OUT19/12283

**Coffs Harbour Bypass (SSI 7666) –  
EIS Exhibition**

Simon Francis  
Acting Manager, Assessments  
**DPIE Water – Strategic Relations**  
25 November 2019

FIGURE 1 PRELIMINARY MIC AND VIBRATION INTENSITY FOR GATLEYS TUNNEL

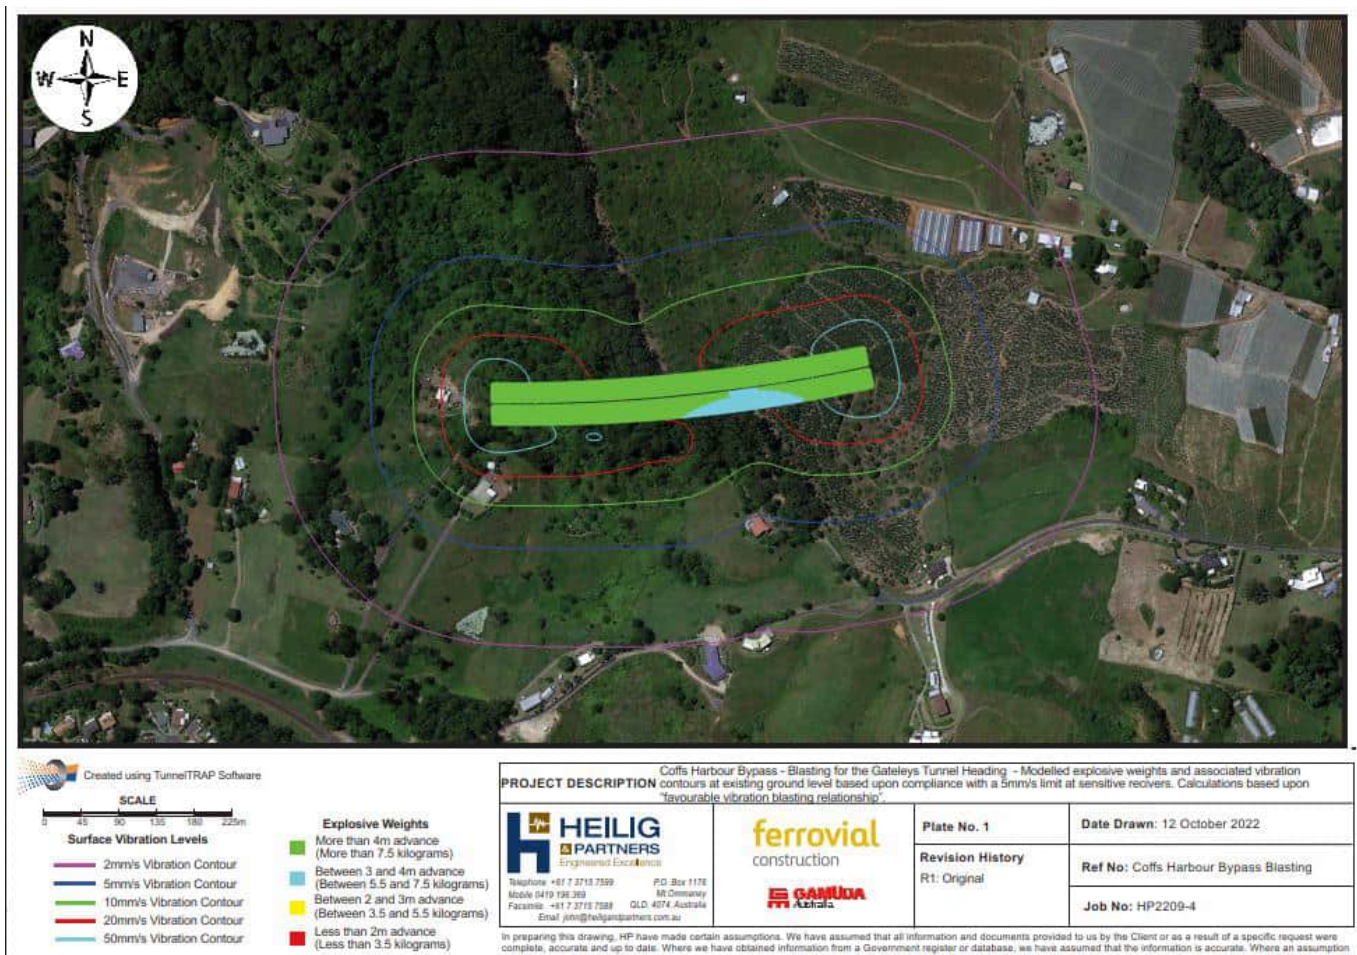
- Consideration should be given to line the Gately's Road tunnel or refine the assessment to evaluate alternative preventative or remedial solutions regarding the quantum of water take. Ongoing groundwater flows must not exceed 1L/s per kilometre. Further detail regarding this recommendation is provided in **Attachment A**.

For recent assessments of the impact of road tunnels on groundwater ingress, RMS and DPIE-Water have established a threshold of 1 L/s per kilometre of tunnel to trigger a consideration that the tunnel be lined, or subject to a more refined assessment that could entertain other preventative or remedial solutions.

In this case, further consultation is needed with respect to the long term discharge volume from the Gately's Road Tunnel. Whilst the Roberts Hill and Shepard's Lane Tunnel are modelled to discharge less than 1 L/s per km, being 0.65 L/s per km (0.123 L/s over 190m) and 0.71 L/s per km (0.2558 L/s over 360m) respectively, the Gately's Road Tunnel is modelled to discharge 1.415 L/s per km (0.6366 L/s over 450 m). Despite this modelling there has been no proposal to line Gately's Road Tunnel.
